T4 PROJECT

RESPONSE TO SUBMISSIONS AND PREFERRED PROJECT REPORT

UMWELT'S RESPONSE TO ECOLOGY MATTERS

Terminal Four (T4) Project

FIG NO. 6 **FIGURE TITLE** Mosquito Creek
Potential Hydrologic Impacts and Mitigation Measures

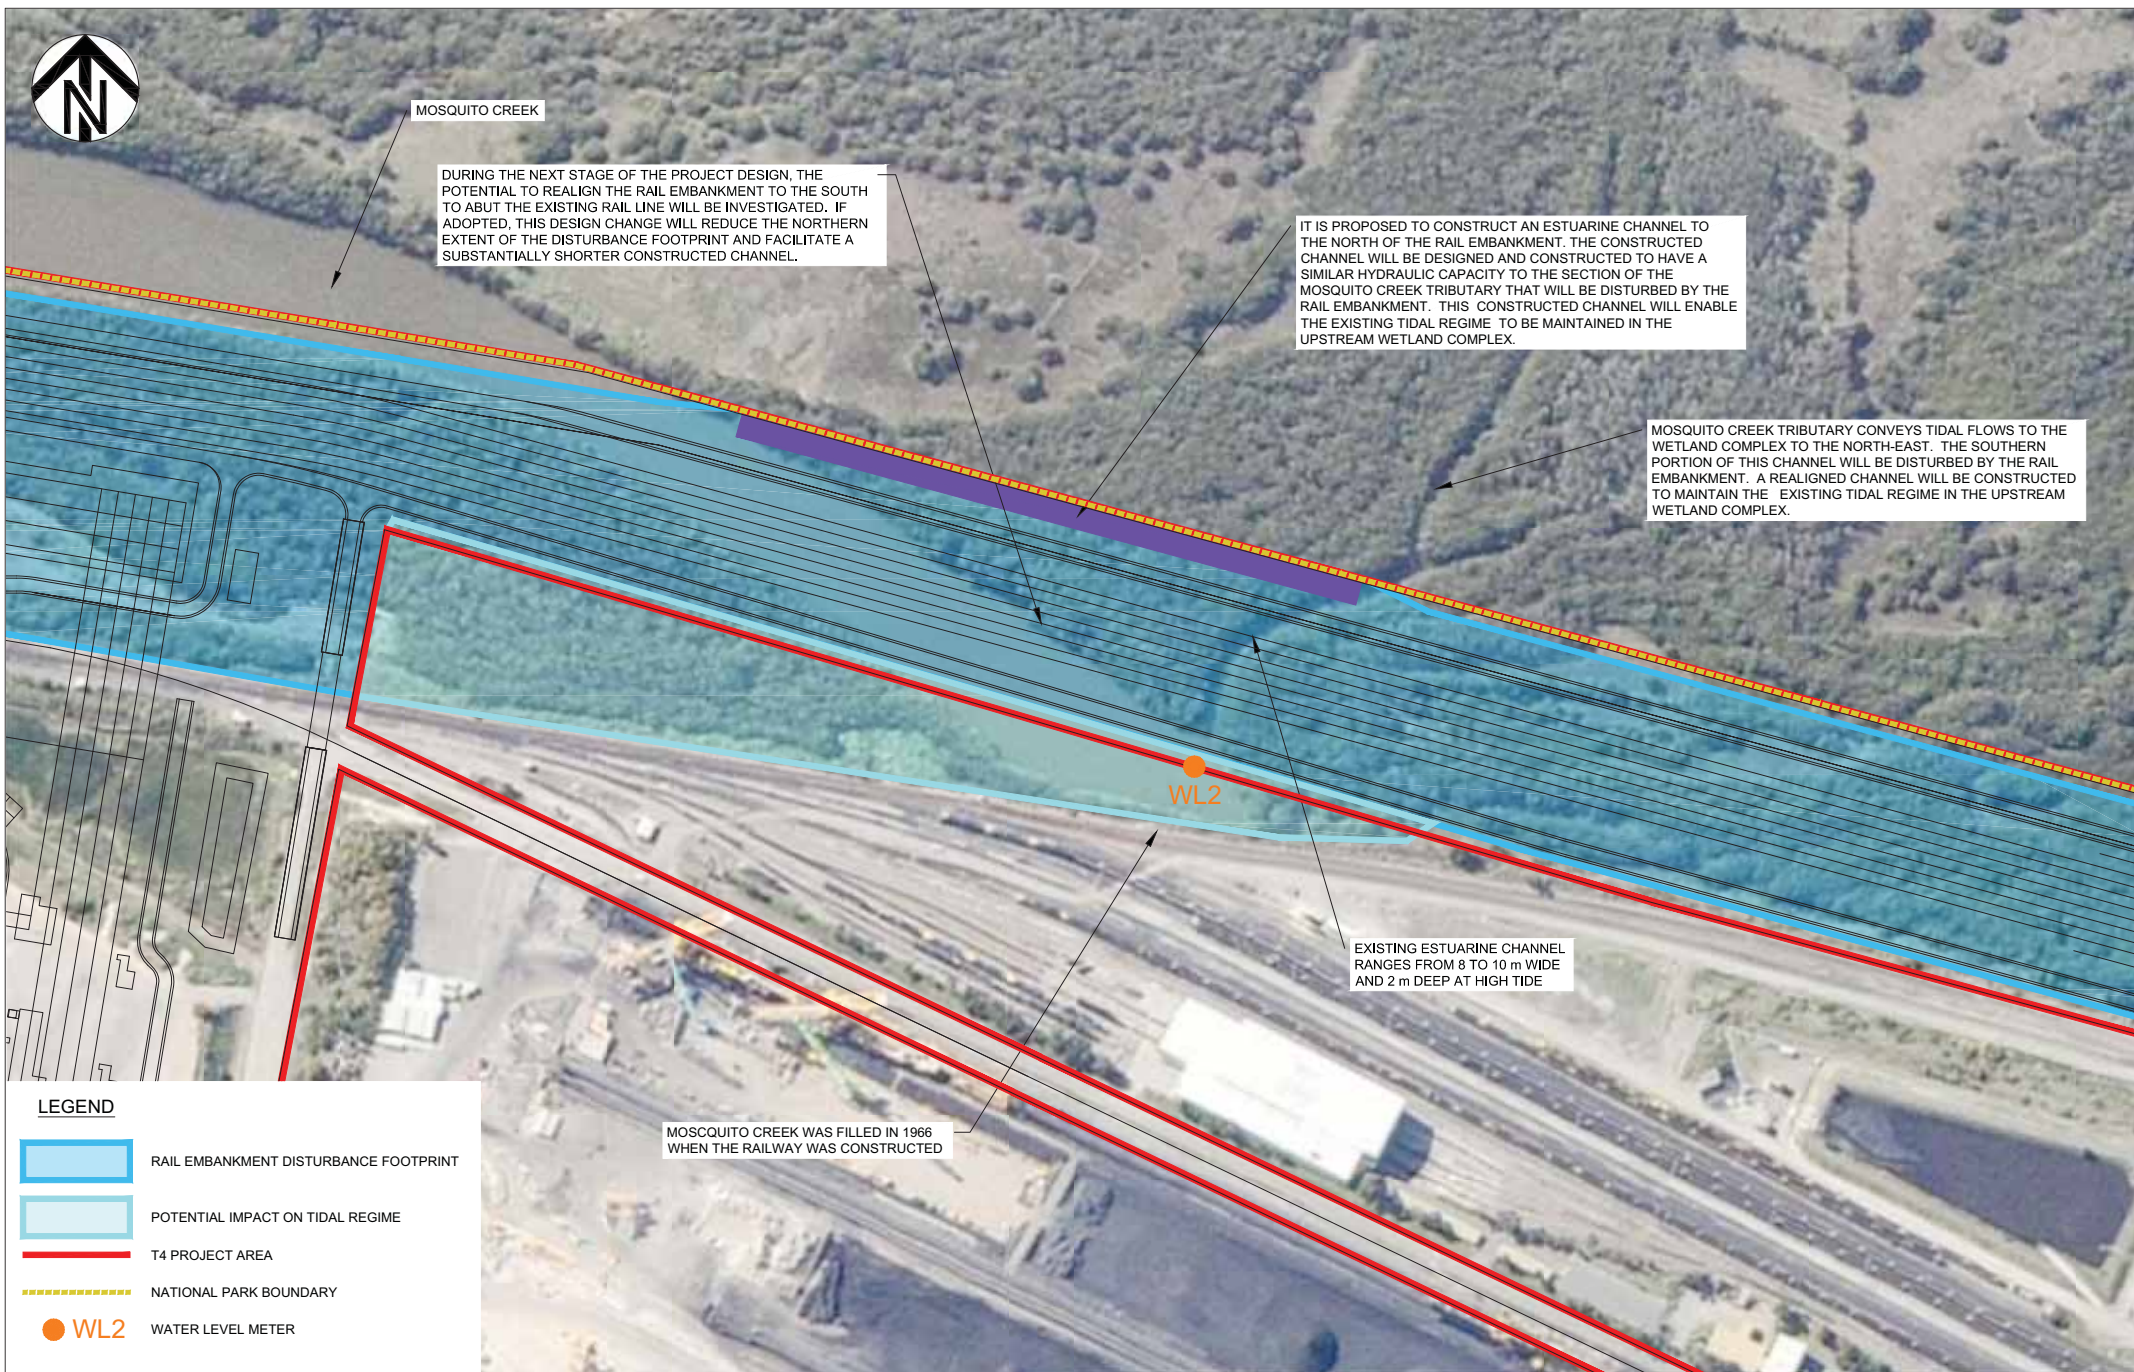
The EA indicates the proponent intends to realign the existing watercourse off Mosquito Creek (Mosquito Creek Tributary, Appendix J, Section 8.2.2, and Figure 6). Appendix J currently states, 'A detailed investigation into the most appropriate construction and re-vegetation techniques will be conducted', indicating a thorough environmental assessment has yet to be conducted on the creek realignment proposal. The proponent needs to provide adequate environmental assessment of the proposal prior to determination of the project.

Mosquito Creek is a substantial tributary of the Hunter River north arm that was historically blocked on its southern entrance with the construction of the railway on Kooragang Island and during the infilling of the island. It is proposed that a channel be constructed to ensure that water flows to the unnamed tributary that feed estuarine wetland habitat to the north is replicated such that there is negligible change to the ecology of this area. The constructed channel would continue to deliver tidal water to the wetlands of Hunter Wetlands National Park and the Hunter Estuary Wetlands Ramsar Site.

As discussed in the ecological assessment of the modified T4 Project (refer to Section 6 of the PPR), the construction of the diversion channel is expected to assist in maintaining flow into the unnamed tributary of Mosquito Creek. It will also result in the loss of approximately 0.2 hectares of mangrove forest in the proposed rail and utility corridor within the T4 project area. The EA assumed that this area would be cleared and the offset package included components that adequately offset the impacts of vegetation and habitat removal from this area. Since the exhibition of the EA, SMEC has modelled and assessed potential impacts to Mosquito Creek and the Mosquito Creek Tributary in detail, including a conceptual design for the proposed diversion channel and modelling of its effectiveness (Appendix L of the RTS/PPR). The modelling indicates that the constructed channel will be effective in maintaining the existing tidal regime in the Mosquito Creek Tributary and adjacent wetlands. Based on the analyses undertaken by SMEC (Section L of the PPR and Appendix J of the EA), any ecological change resulting from indirect impacts to the Hunter Wetlands National Park and the Hunter Estuary Wetlands Ramsar Site is expected to be negligible.
